Design Review Panel Meeting 18 - Minutes

Date: 13 October 2015

No.	Action	By
1	NW plot - Section 96	
1.1	Lend Lease indicated that they had secured a tenant for the NW Plot commercial building and introducing minor amendments to meet their needs. The development includes an integrated fit out.

Sheet title
COMPARISON BETWEEN DA
SSDA4 VS. SECTION 96 - EAST
ELEVATION

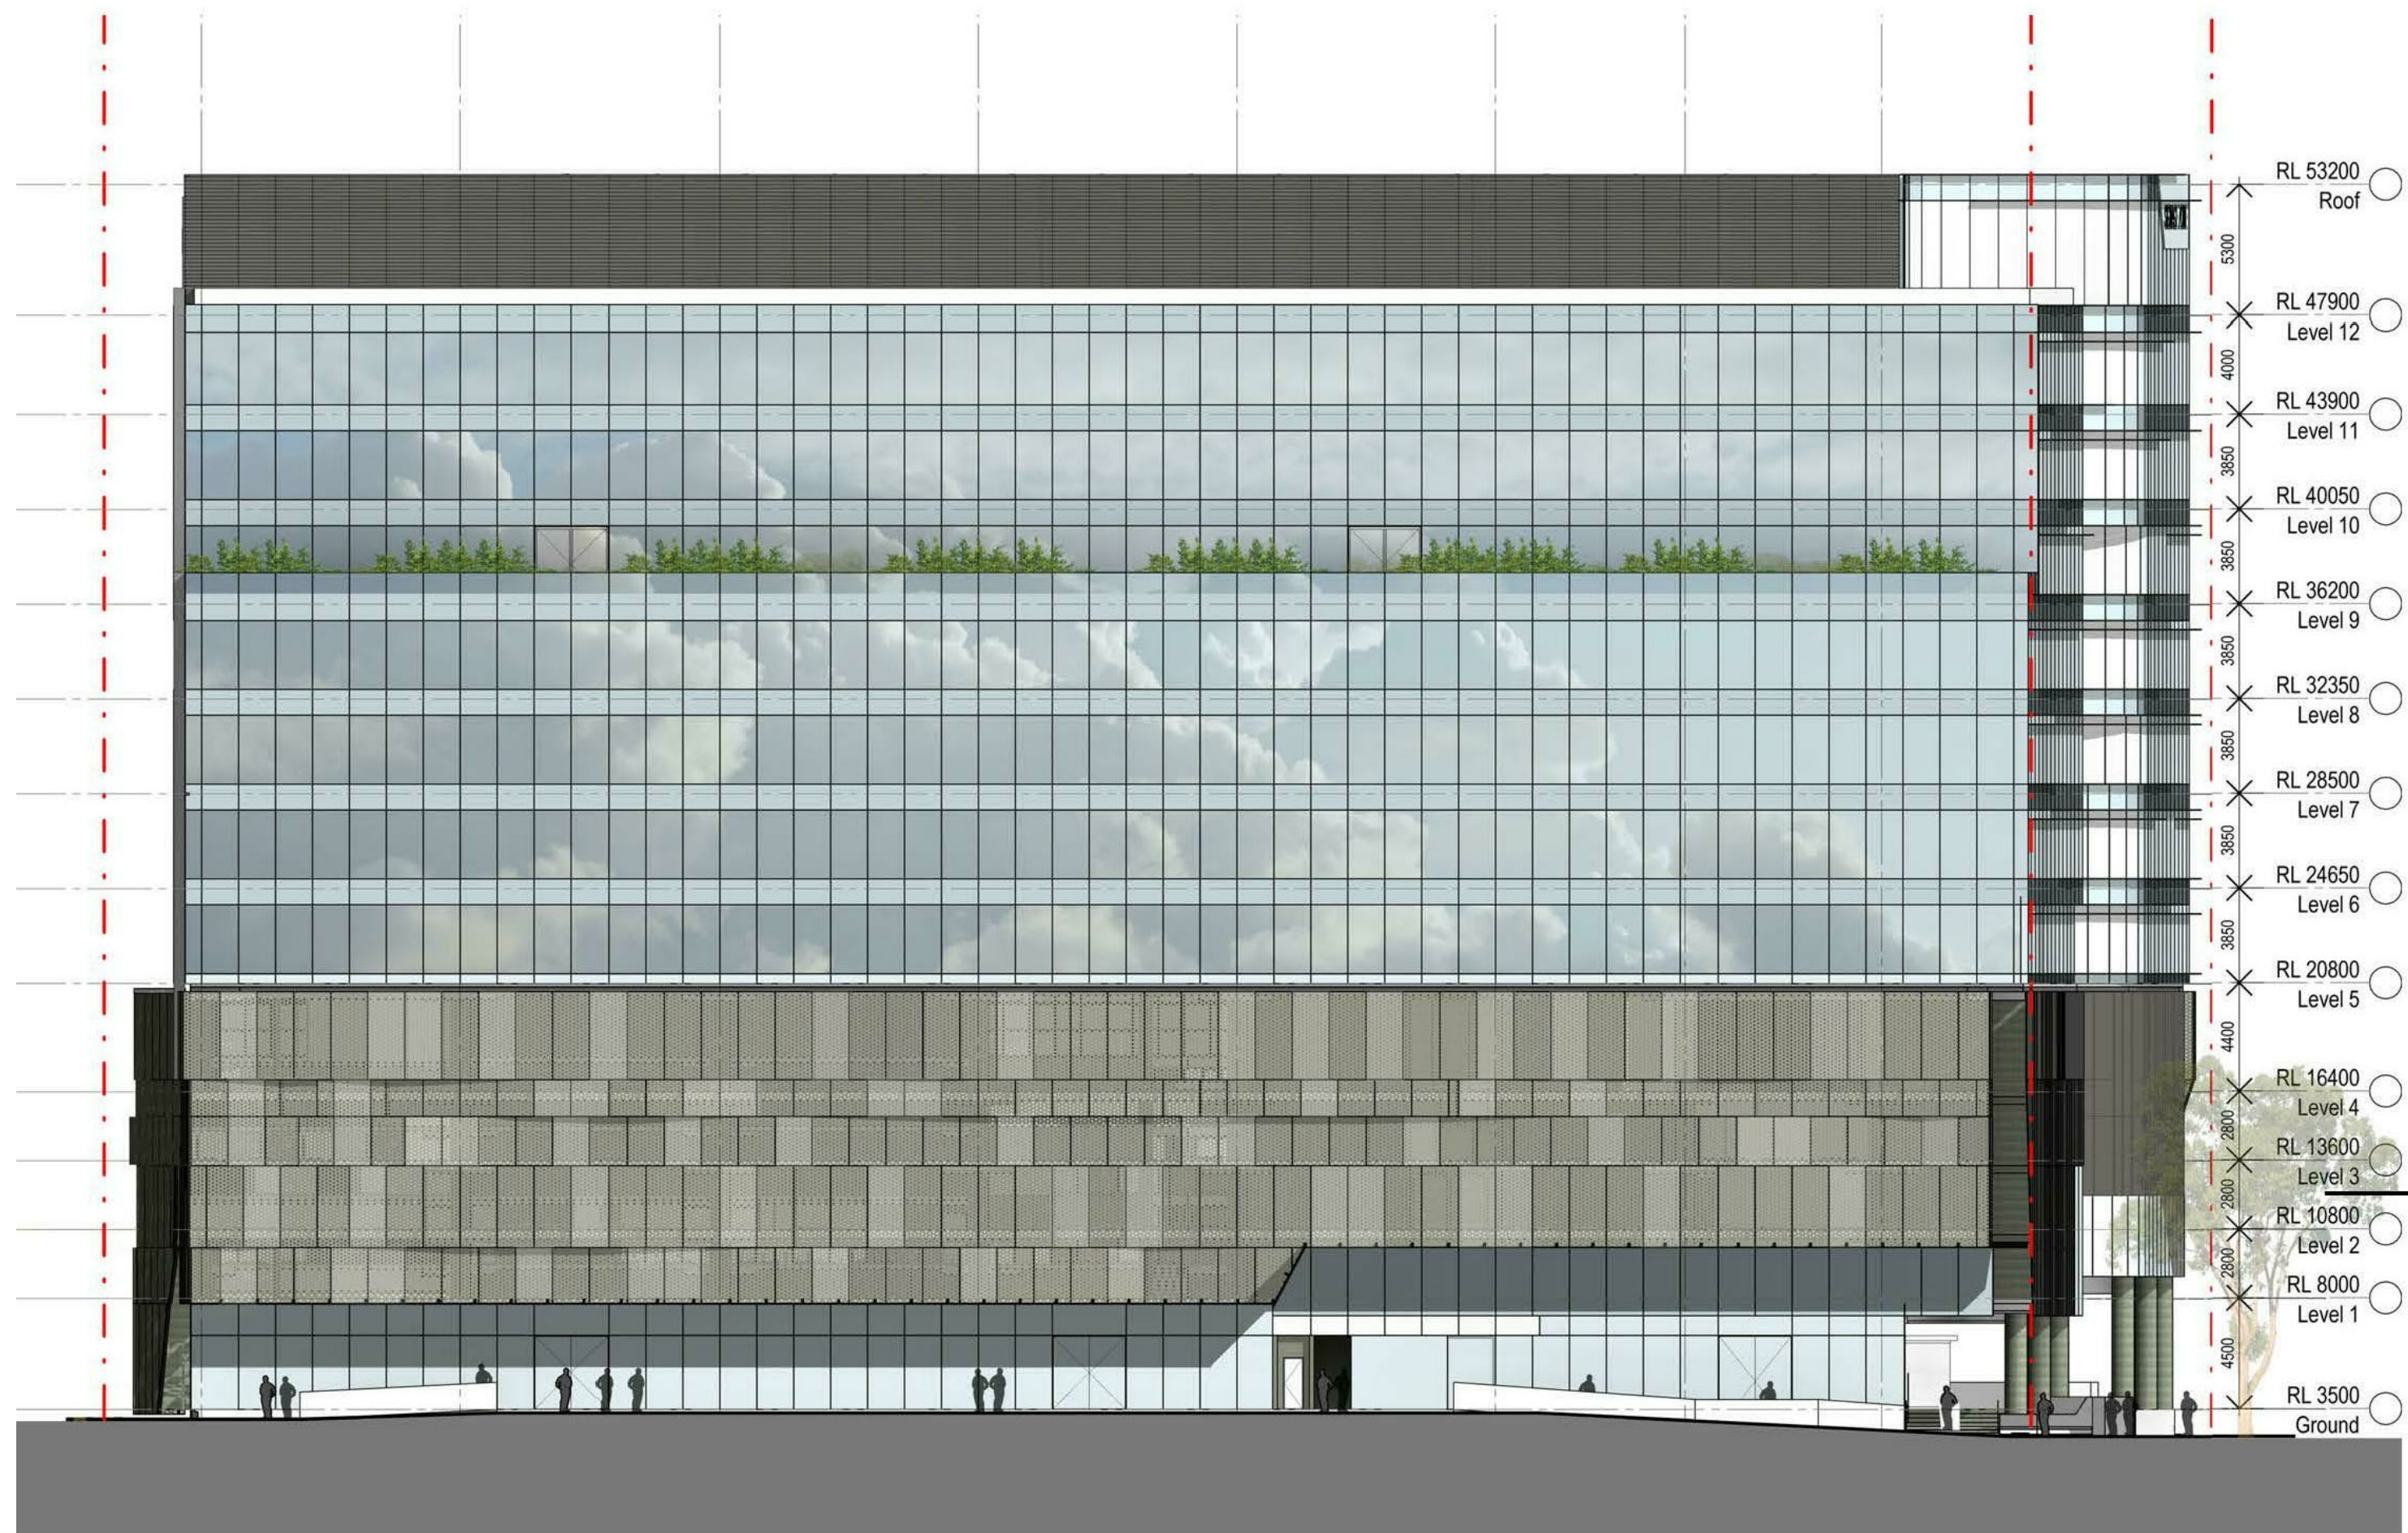
1.2	Woods Bagot presented the changes North West Plot:- • South East corner of building has been redesigned. • Awning along Dickson Lane reduced. • Entry Awning along Boulevard enhanced • Fire escape route on suspended walkway on Western side. Woods Bagot indicated that zinc metal cladding material is to be used to the front lower façade, anodised panels along Dickson lane with 3 different shapes and 3 types of perforations. Woods Bagot presented the changes to the floorplan over the different levels. • Increased size of the Atrium up through the building • Glass lift cars and open shafts • Additional floor space due to redesign in plant room and storage. • Introduction of additional office space on Level 12 and a roof terrace. • Solar panels incorporated on the roof. DRP questions the visibility of the roof to adjacent buildings. Lend Lease indicated that the North West Plot was the same height as the theatre and the roof would be visible from the adjacent residential towers. Lend Lease indicated that they are aiming for 6 Green Star rating and 5 Star NABERS rating for the North West Plot. Woods Bagot presented the changes to the elevations of the building. • North Elevation has the number and depth of vertical fins reduced due to revised reflectivity study. The development in the signage zone due to the securing of a tenant and the glazing on the lower levels embedded into the cladding. • Eastern Elevation has a new entry awning with a signage zone. The

south east corner has been refined to create an architectural feature visible from Darling Square. The metal cladding material on the lower level has been revised to a zinc cladding material and frames the glazing of the gym and end of trip facilities. The South and West elevations have been refined and a further development of the signage zone on the top of the West elevation. Woods Bagot indicated after questions for the DRP that they are working closely with Aspect Studios for the integration of the ground plane finishes and signage into the surrounding Boulevard, laneway and pedestrian areas. The DRP indicated that the changes presented improved the building in form and design.	
2	Next Steps	
	Due to the exposure of the zinc cladding to the Boulevard and Darling Square, the DRP would like to ensure that the chosen material is suitable. The DRP would like to see samples and details of the material to be used.	LL
